Planning Application Ref: BE/81/20/OUT

Location: Chalcroft Nursery, Chalcroft Lane, Bersted, PO21 5TS

Description of works: Outline application with some matters reserved for the development of 20 residential dwellings, 2,240 sqm of commercial space (Use Class A1, B1(b) B1(c) and B8), landscaping, access, parking and associated infrastructure

Tree Officer / Parks and Greenspace Team

Drawing Title:
**Appendix 3A - Tree
Constraints Plan - Existing**

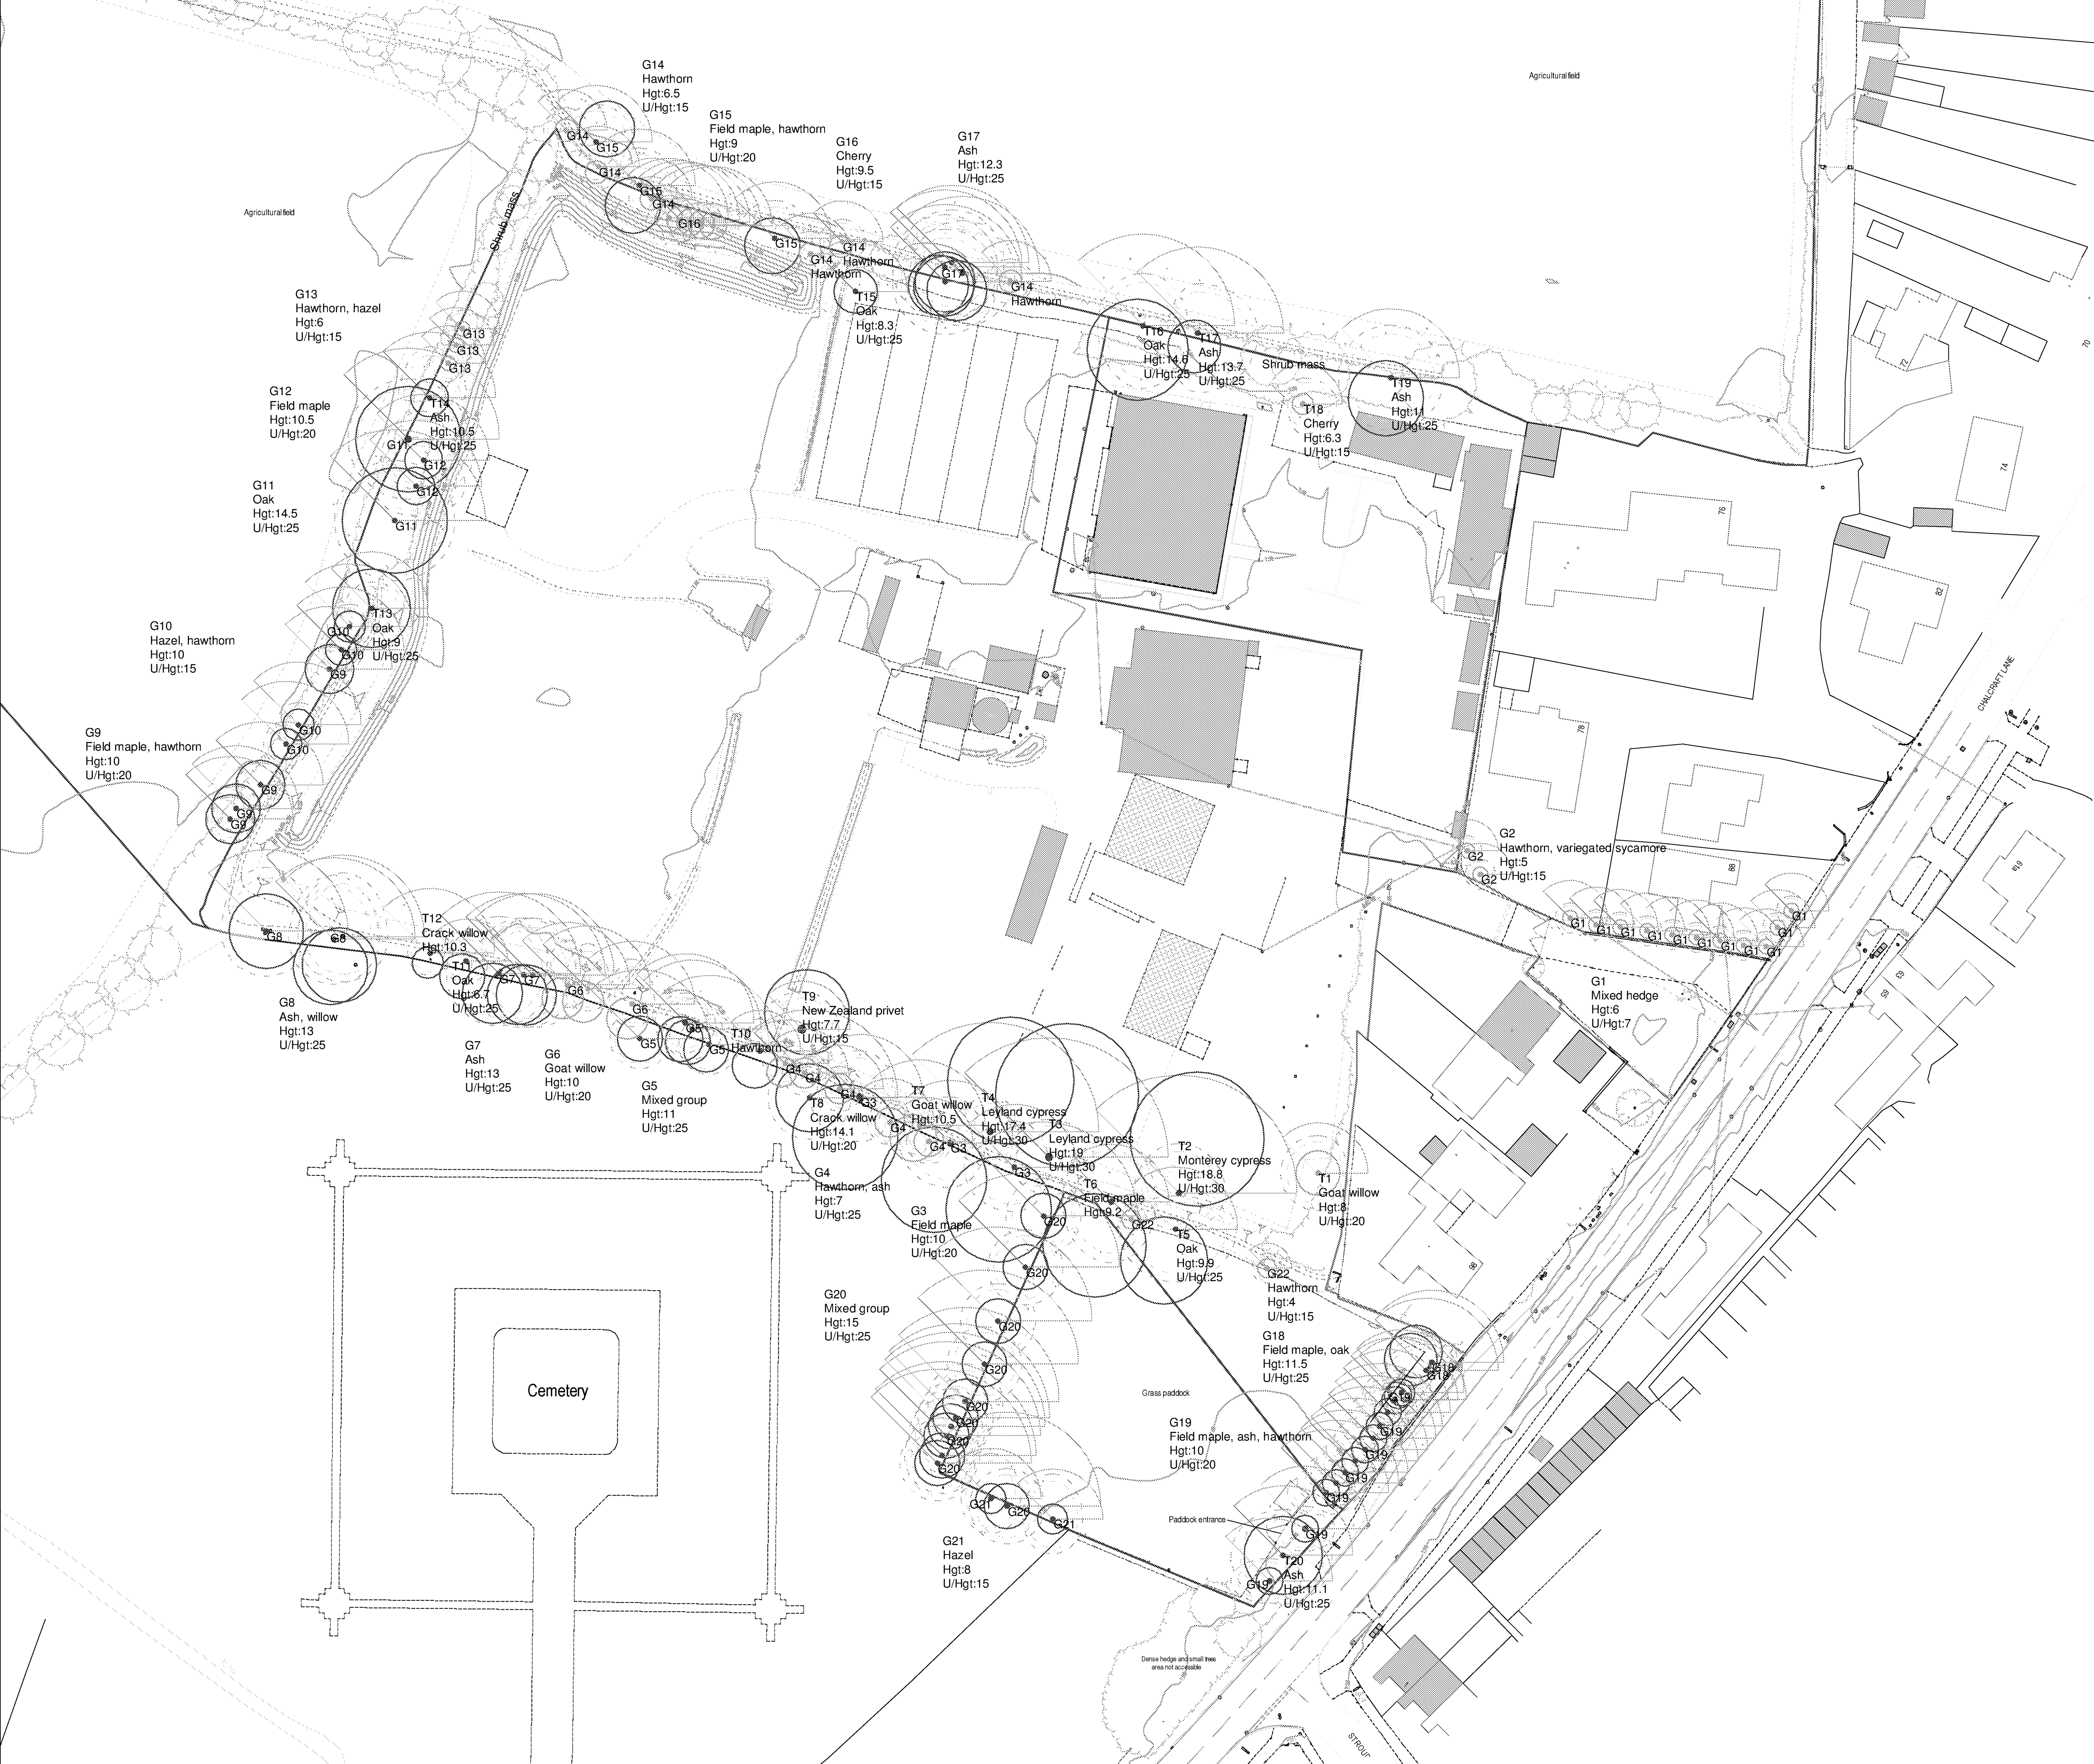
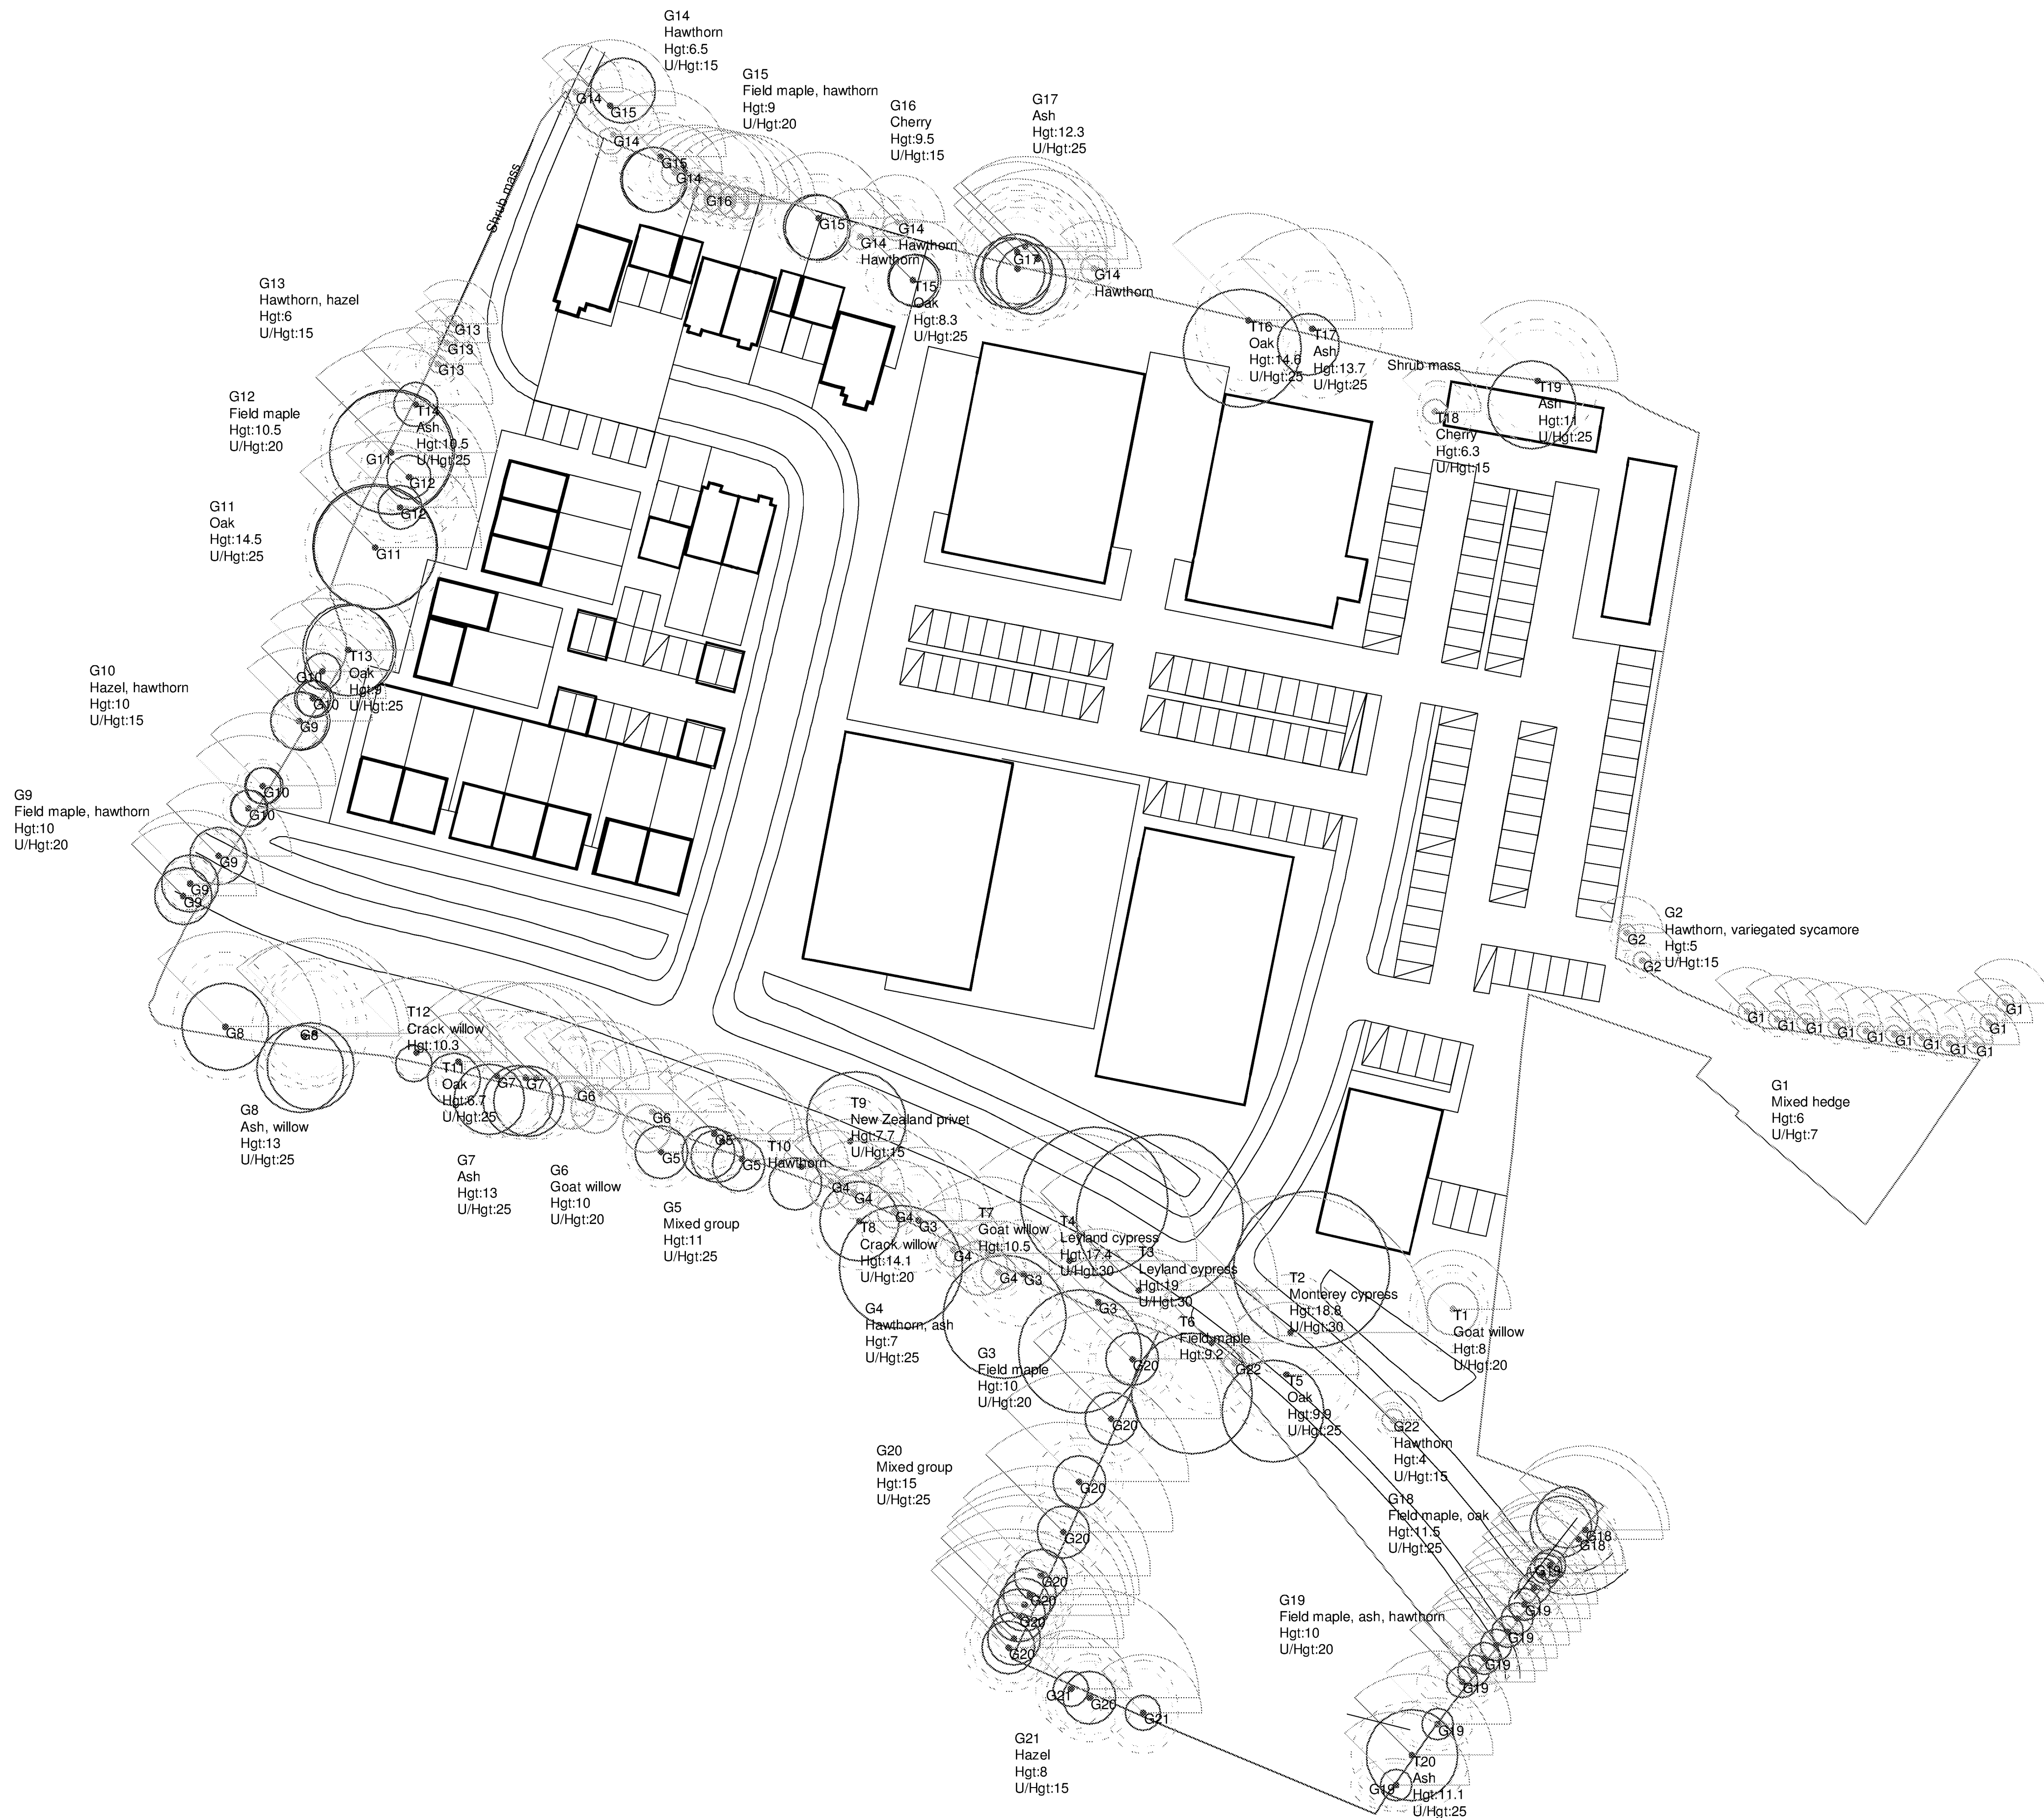
- The tree population on or overlapping the site is confined to the perimeter, which provides a clear opportunity to achieve harmony between higher value trees and any construction. Those trees to be retained have mostly been afforded sufficient room to allow future growth without significant constraint.

I draw attention to the nominal root protection areas (RPA) of retained on/off-site trees and their growth potential as obvious constraints to the siting of any SUDS (e.g. attenuation pond, swale) or introduction of subterranean utility apparatus.

- Trees of moderate-high quality and landscape value will have to be sacrificed to provide the main access serving (logical) arterial road onto/through the plot. This loss of established tree cover should not incur undue detriment to the visual amenity of surrounding area but must be adequately compensated for within soft landscape proposals.
- If this comes back in as a full and detailed application it will need to be supported by an **Arboricultural Impact Assessment and Method Statement Report** inclusive of a **Tree Protection Plan** defining which trees are to be retained and which trees are to be removed and how they would propose to protect the retained trees and if necessary mitigate any adverse impact on the root systems of these trees – thus complying with the recommendations of BS5837:2012 – Trees In Relation to Construction.

- As it stands, I see no reason to object to this outline proposal on arboricultural grounds.
- I recommend the making of a Tree Preservation Order in respect of **G11 (part) and T16** (applicant's reference) to preserve their place in the landscape. The TEMPO forms and GIS plan necessary for the making of this Order can be found at the following location [REDACTED]
[REDACTED]
